COMMUNITY SERVICES DEPARTMENT

February 4, 2020

**Subject: Man Cave at Bentgrass Meadows Drive Minor Subdivision
(Final Plat)**

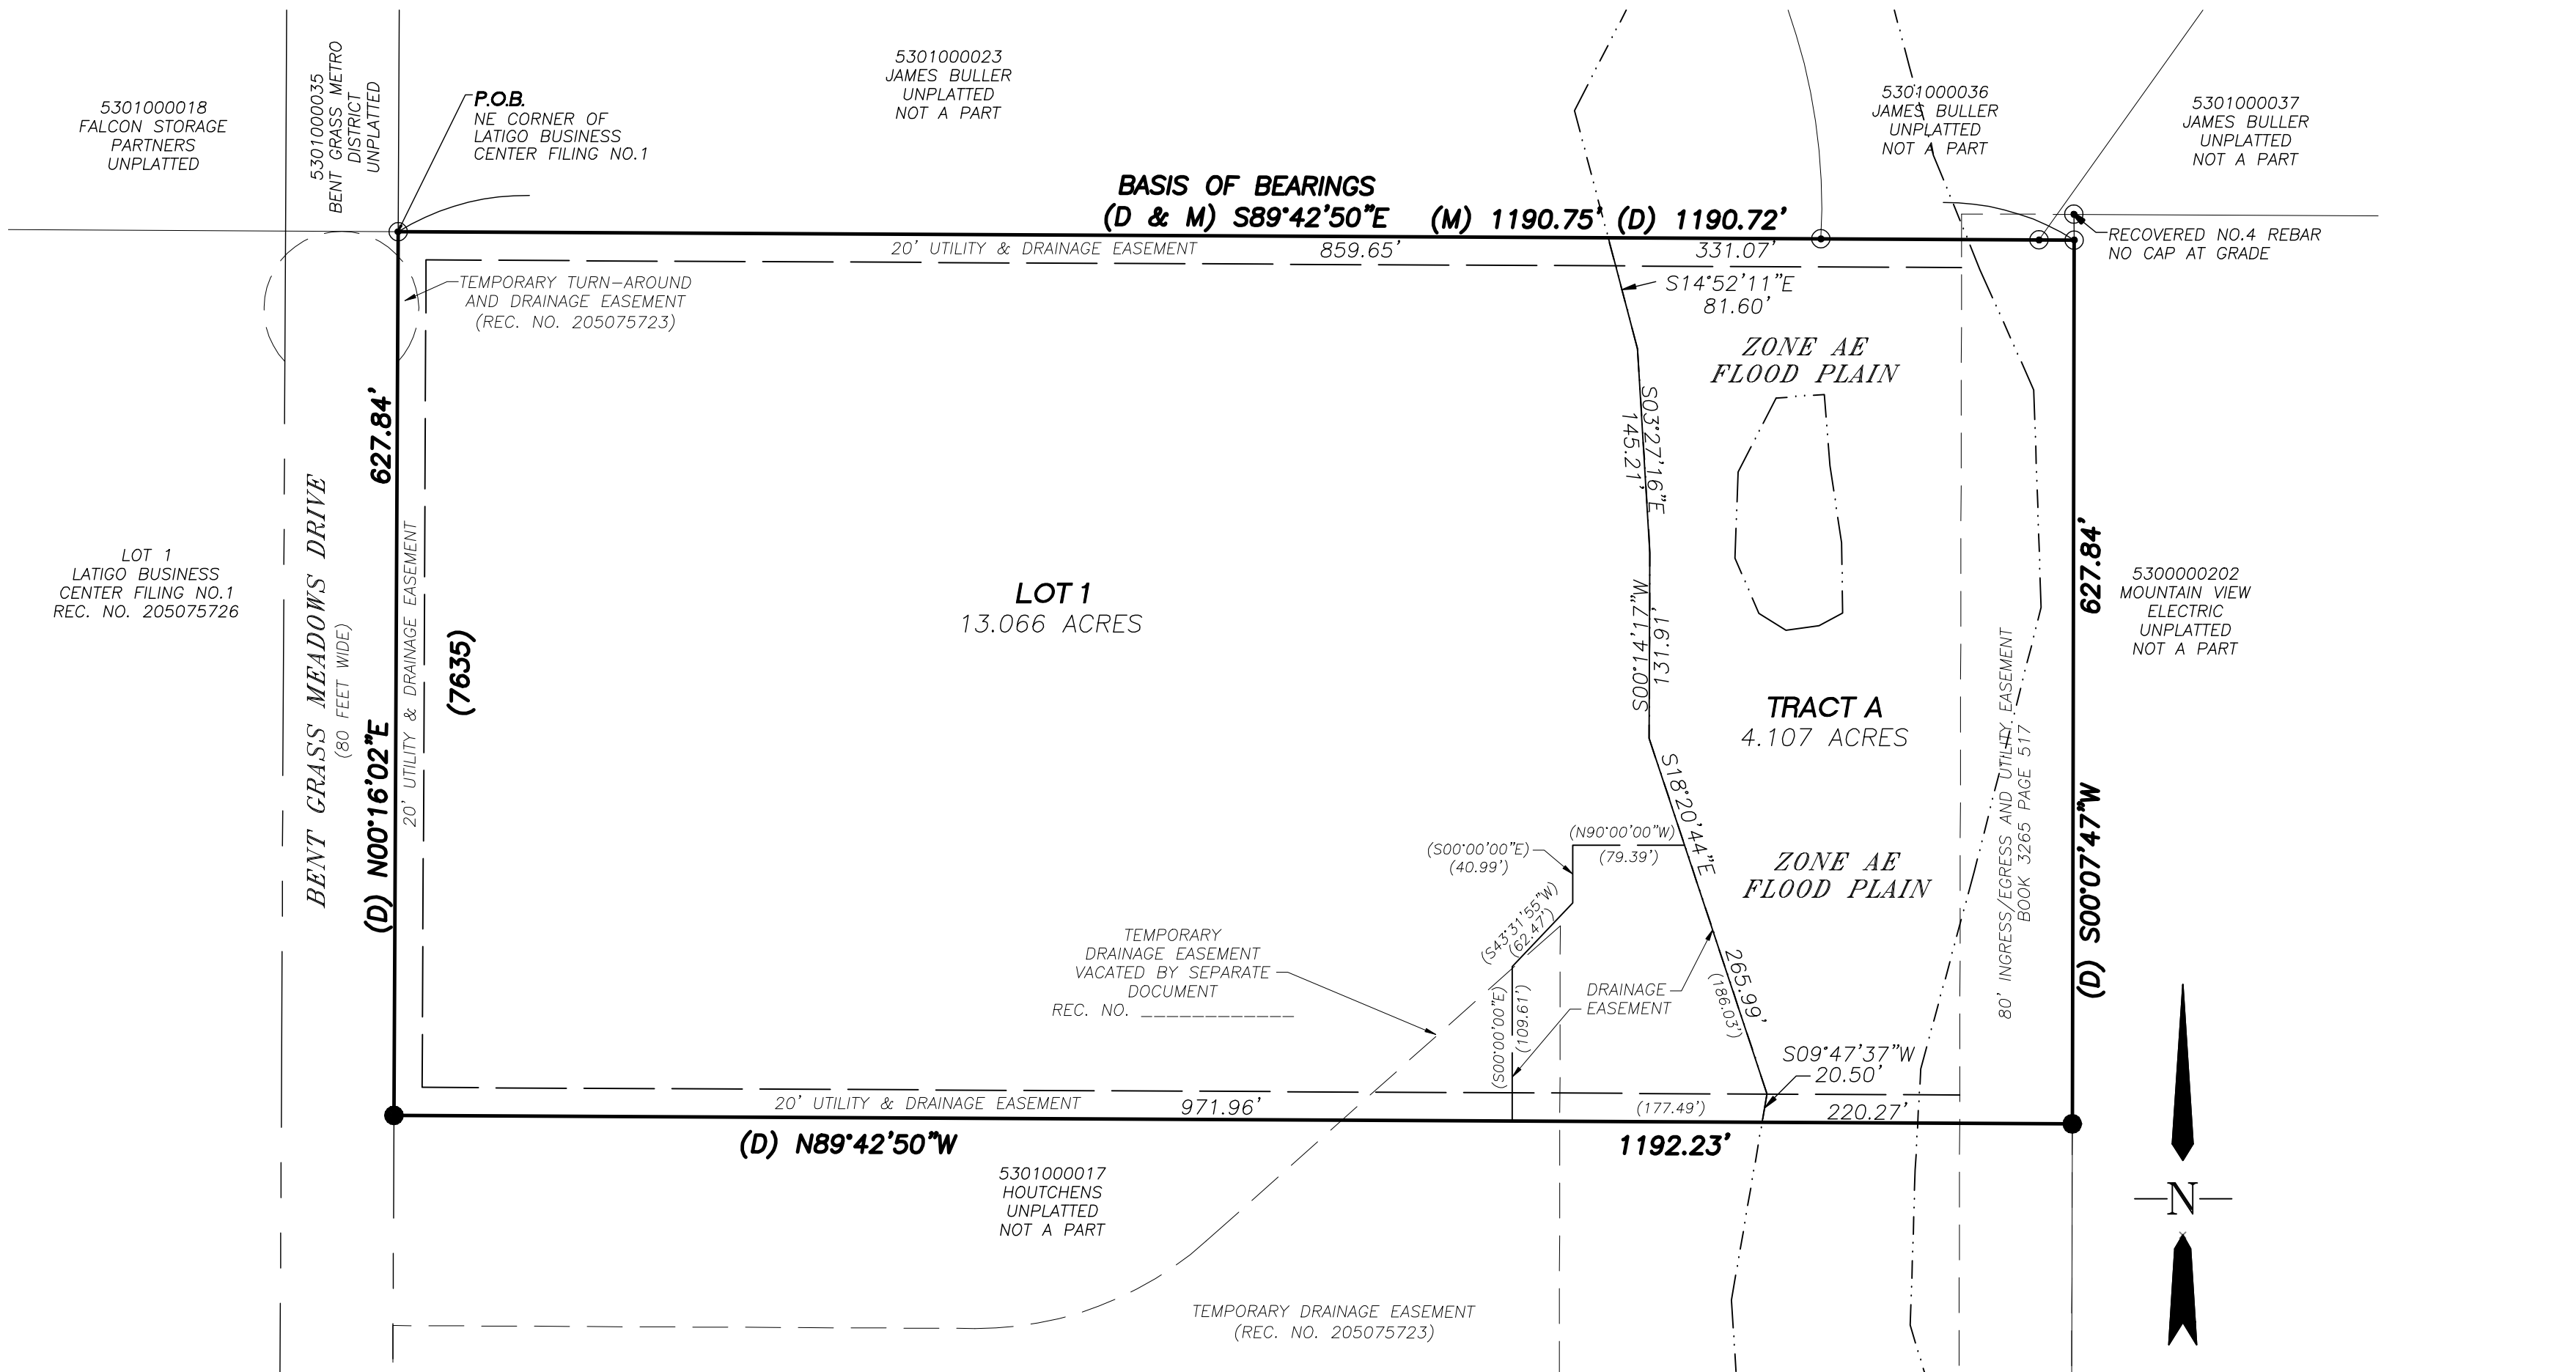
County Parks requests trail easements where development projects impact proposed County trails. As it pertains to this application, the County requests that the landowner provide a 25-foot public trail easement along the east side of the stream that bisects the property, which will allow for public access,

as well as construction and maintenance by El Paso County of the Woodmen Hills Secondary Regional Trail, and this easement shall be shown and dedicated to El Paso County on this Final Plat.

Staff Recommendation: Recommend to the Planning Commission and the Board of County Commissioners that the approval of Man Cave at Bentgrass Meadows Drive Minor Subdivision include the following conditions: designate and provide to El Paso County a 25-foot trail easement along the east side of the stream that bisects the property, which will allow for public access, as well as construction and maintenance by El Paso County of the Woodmen Hills Secondary Regional Trail, and this easement shall be shown and dedicated to El Paso County on this Final Plat.
